Review Response

Project: Mak Remodel – Mercer Island
Site Address 6521 80th Avenue S.E.
Mercer Island, Wa 98040

Permit #(s) Building Permit #2204-166

RE: Response to Review/Screening comments dated 5-26-22

SCALE: 1/4" = 1'-0"

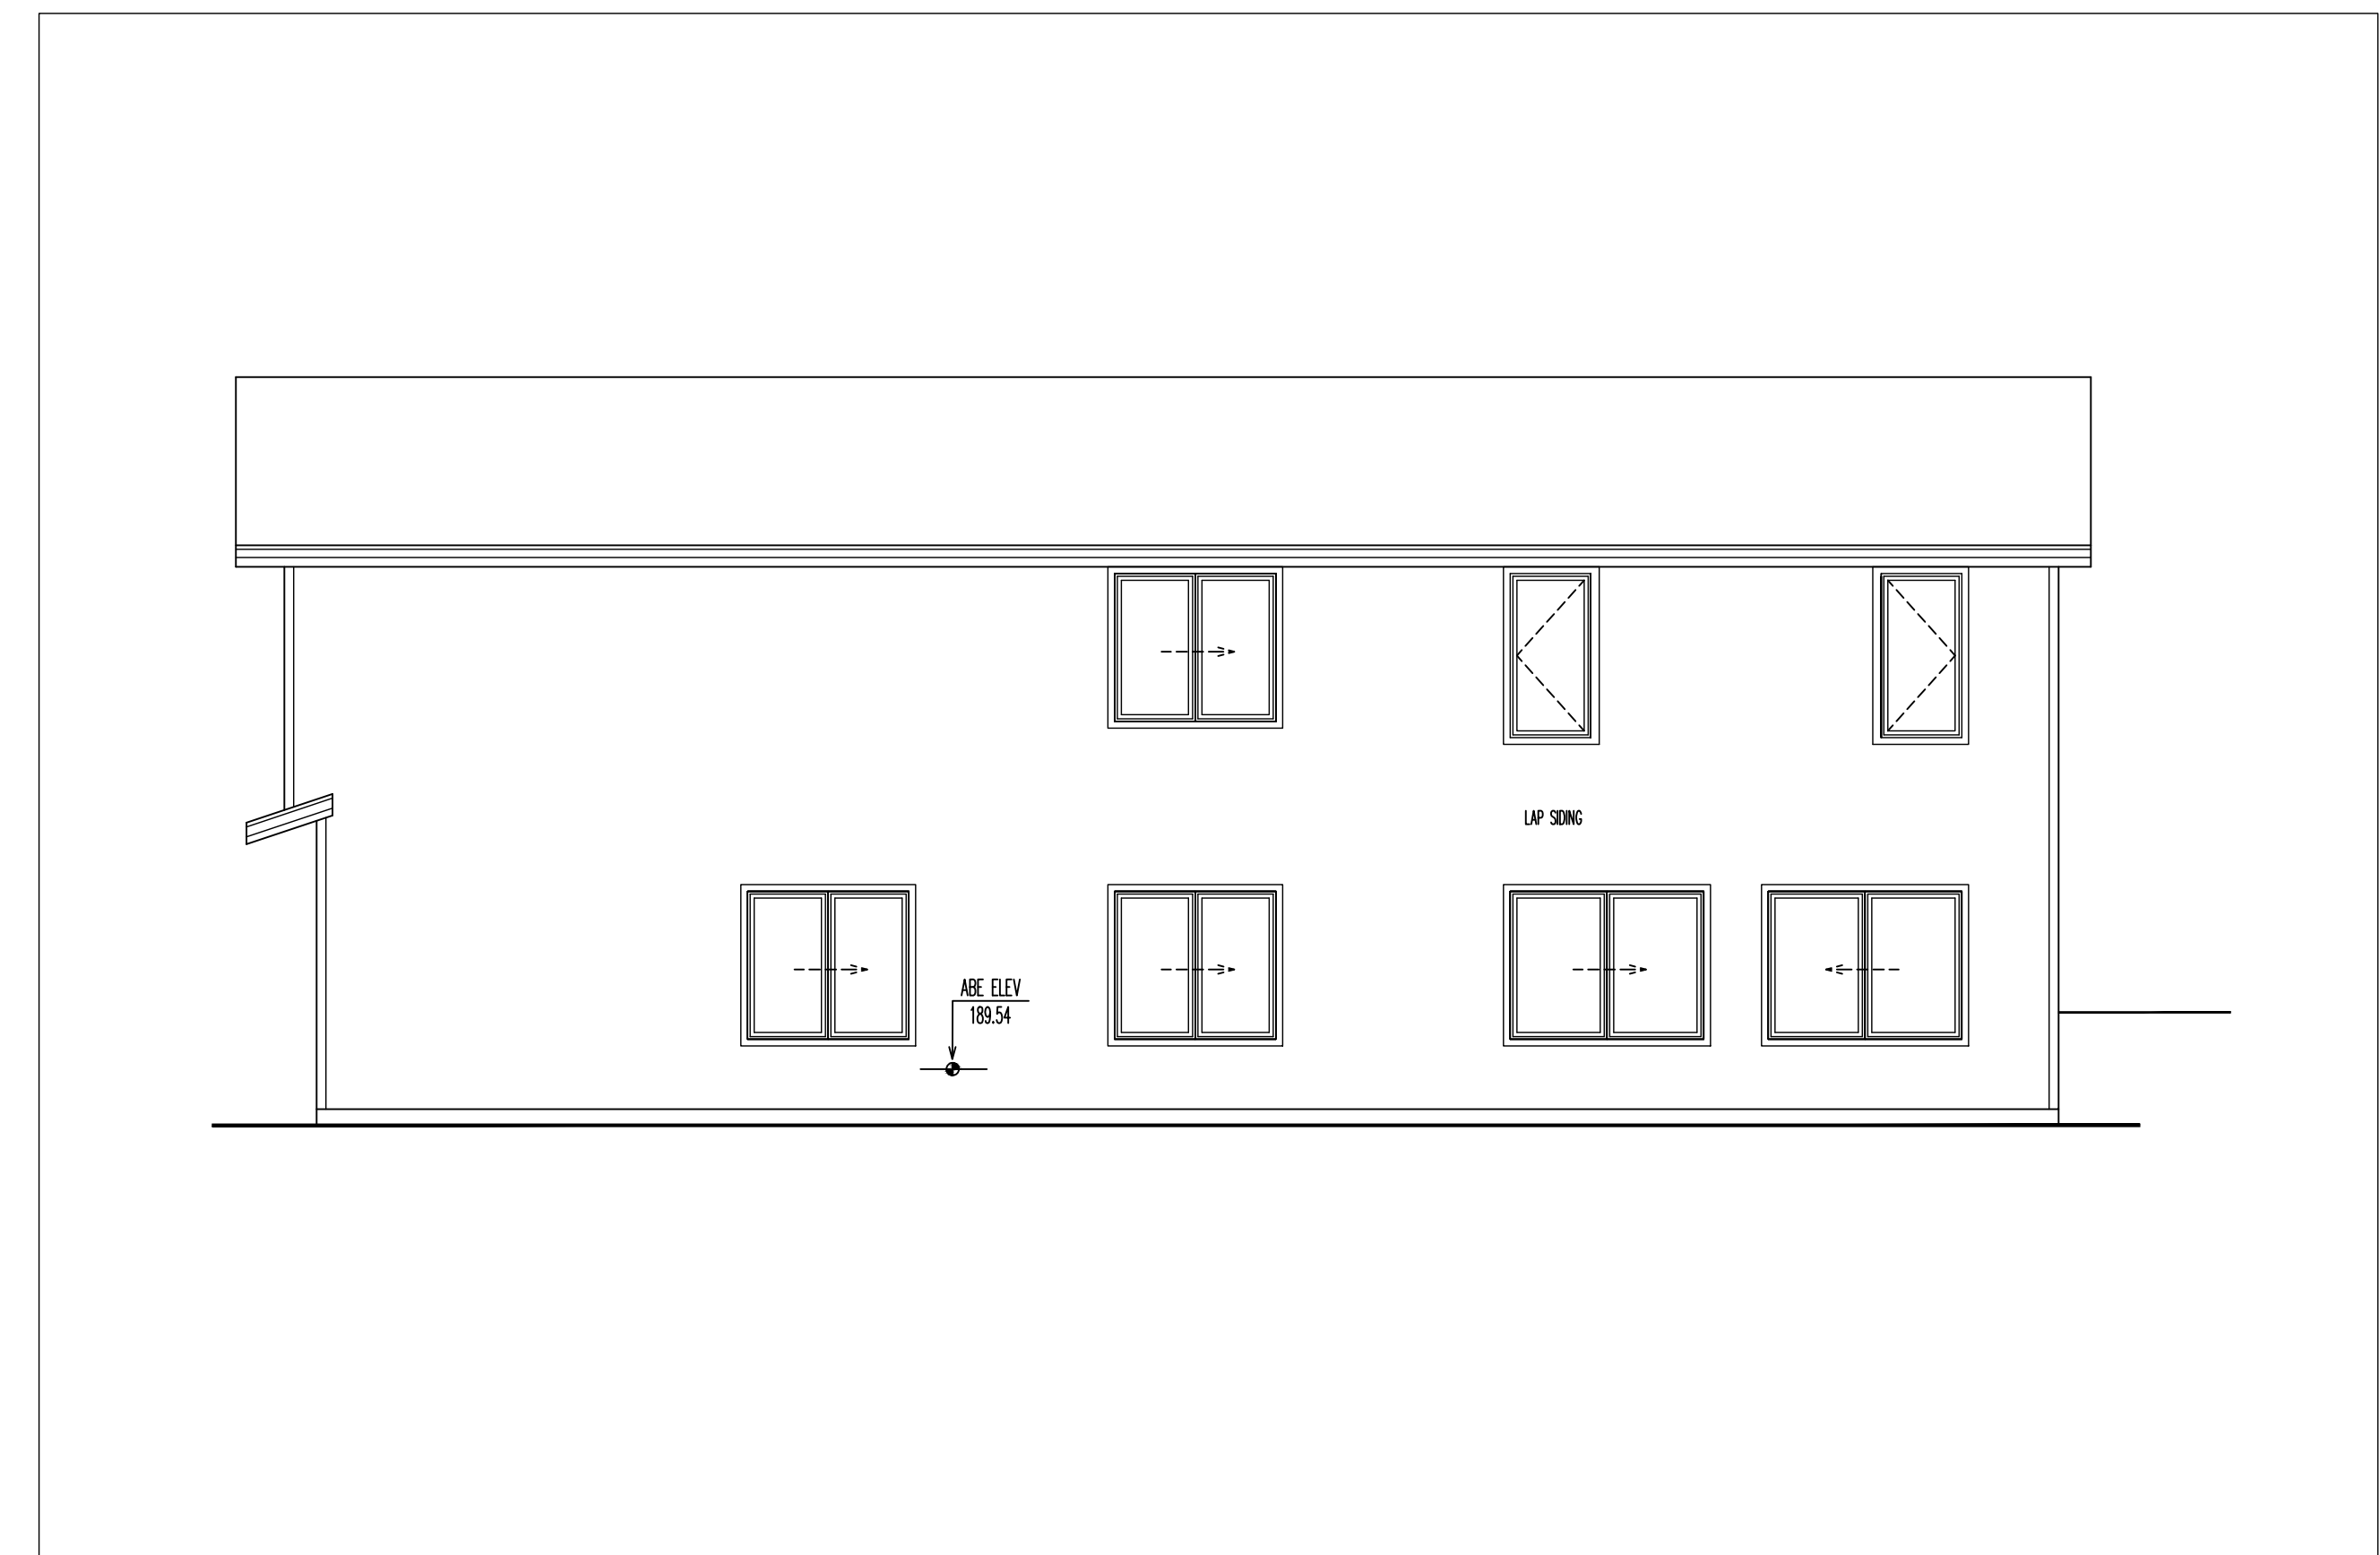
1. PREVIOUSLY ADDRESSED COMMENT: North Elevation is now included on Sheet #A5.

Site Plan

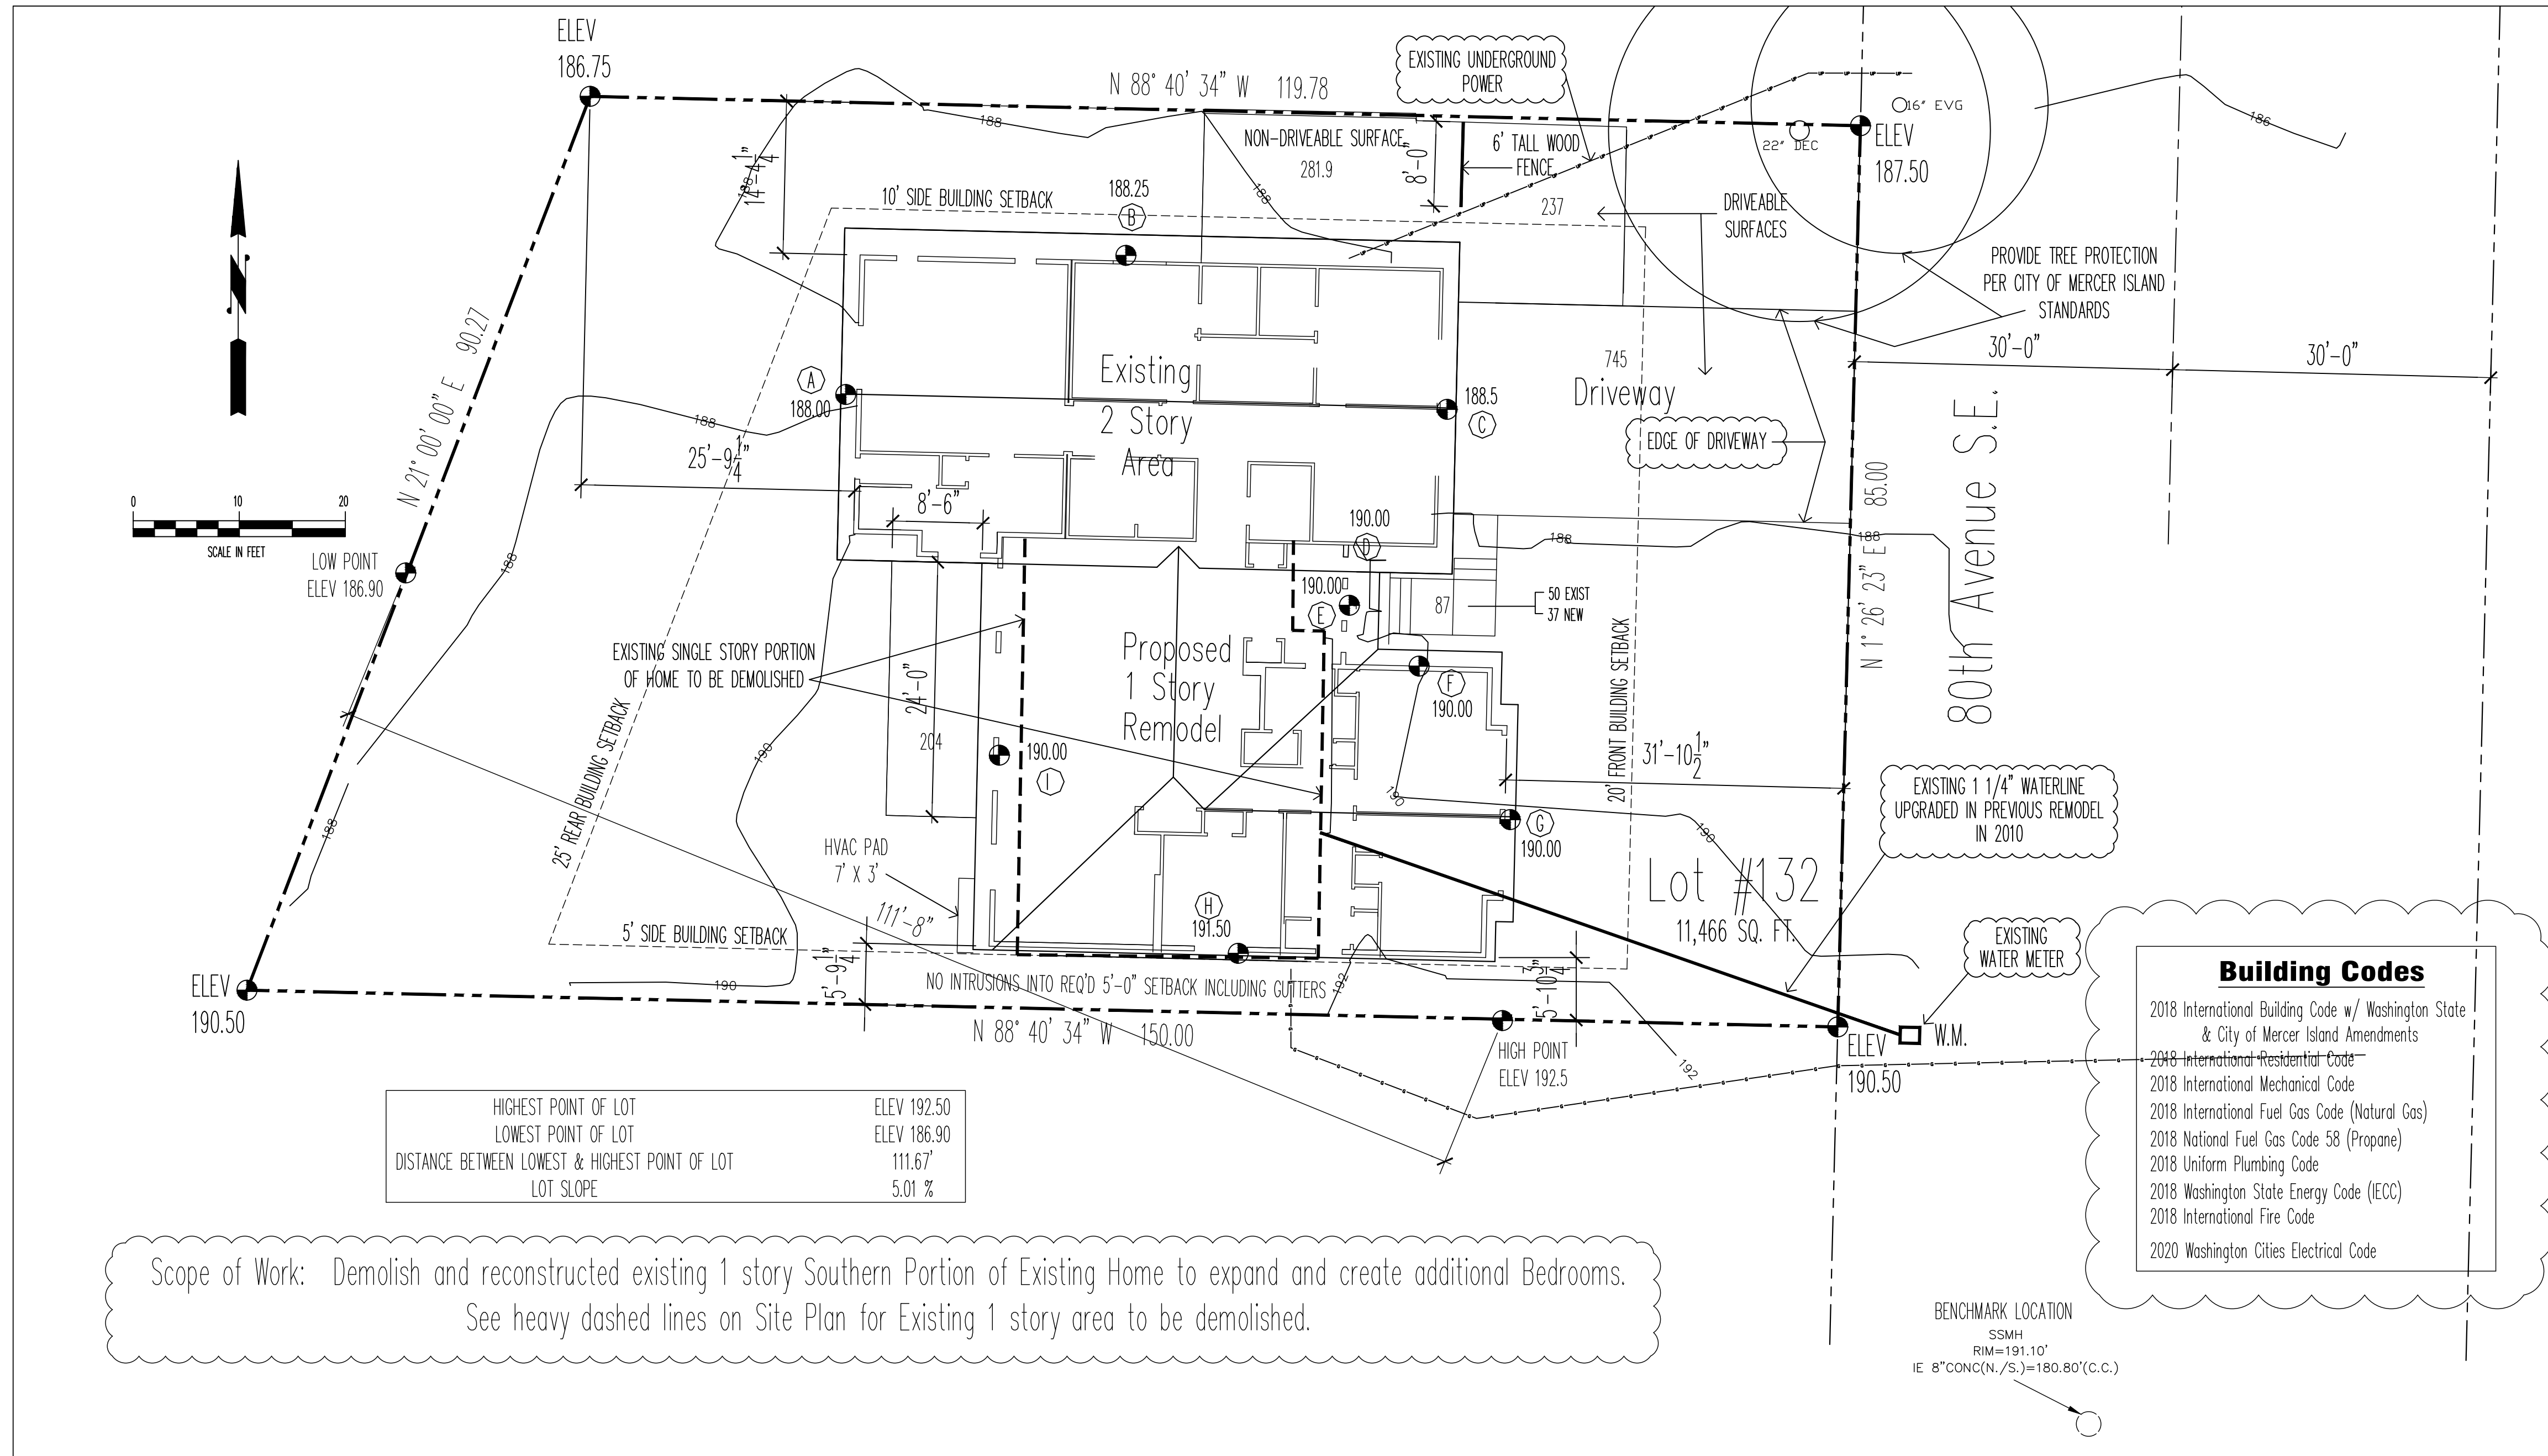
1. Site Plan ST1 Calculations have been updated in their entirety. We reduced the area of the building slightly and shifted the Southern Wall North, in order to provide overhangs/gutters that do not intrude into 5' sideyard setback. Roof Plan also updated to show new overhangs.

1. PREVIOUSLY ADDRESSED COMMENT: Site Plan ST1 has been updated to note the Monitored Fire Alarm requirement.

1. PREVIOUSLY ADDRESSED COMMENT: Site Plan ST1 has been updated to show Tree Protection required at NE Trees.
